February 14, 2020

RE: **Royal Coffee Roasting Co.**
2509 San Mateo NE
Grading and Drainage Plan
Engineer's Stamp Date: 2/7/20
Hydrology File: H17D116

Based on the submittal received on 2/10/20, the Grading and Drainage Plan cannot be approved until the following corrections are made:

1 GRADING & DRAINAGE PLAN

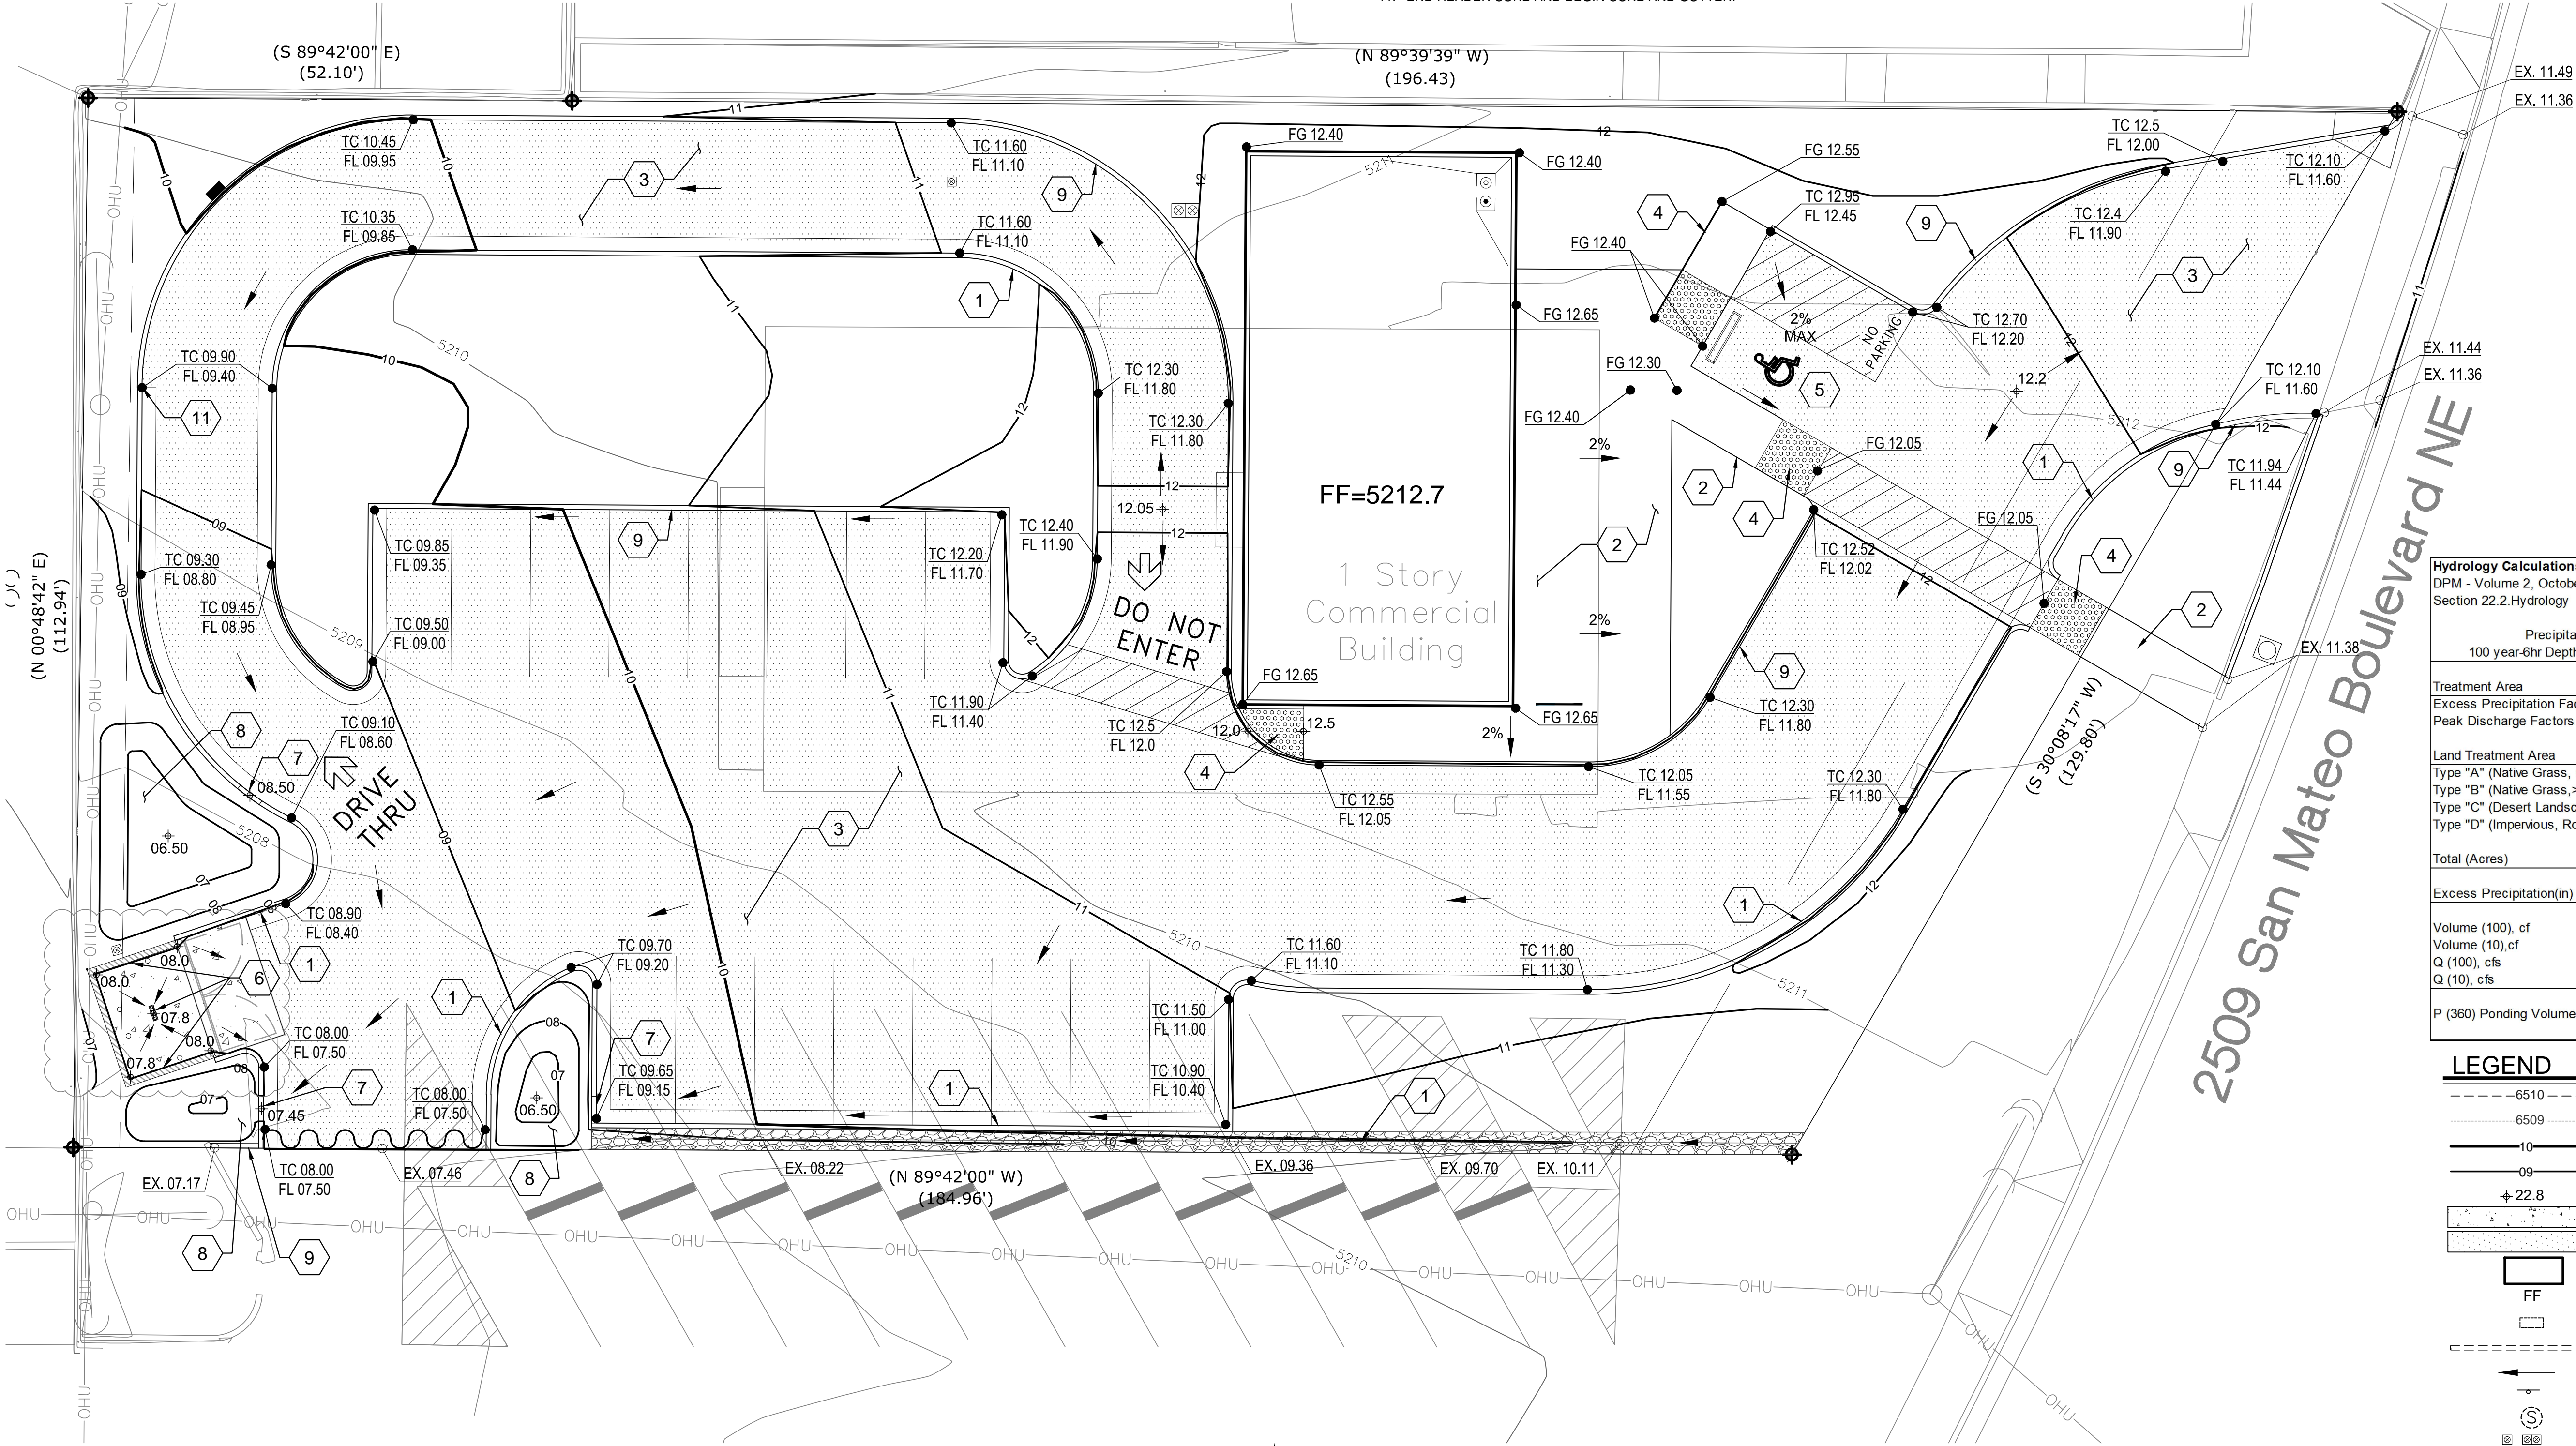
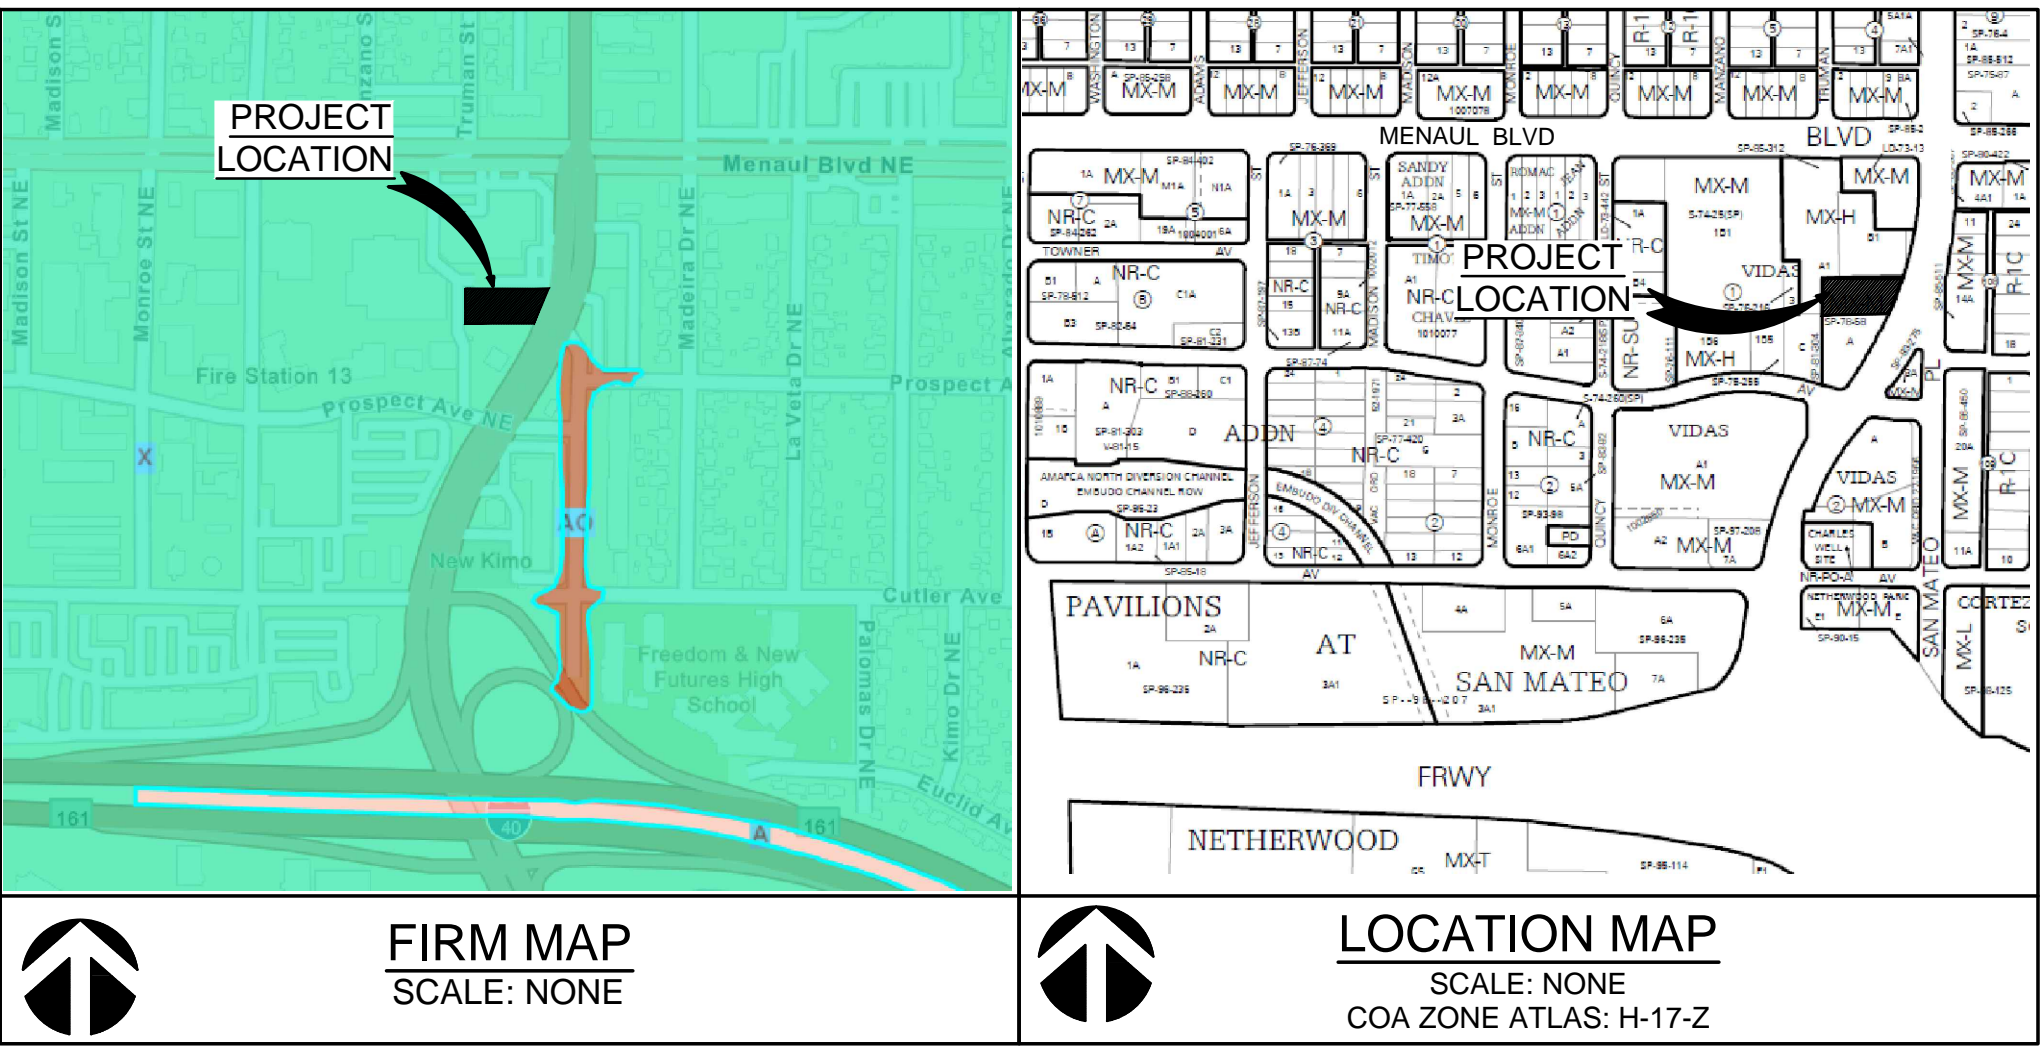
1. Include project benchmark and datum; all existing survey, proposed grades, and benchmarks must be provided in NAVD 88.
2. For trash enclosures serving food service developments, demonstrate *control of liquids from dumpster areas* per DPM Chapter 22.9.E, Table 1 by: containing runoff from the dumpster area, preventing outside drainage from entering the dumpster area, and discharging to the sanitary sewer. If this information is on the utility plan please provide it, or show on the grading plan.
3. Because these corrections are minor, the administrative resubmittal fee of \$40 may be used. Please include a copy of this letter when resubmitting in order to receive the reduced fee.
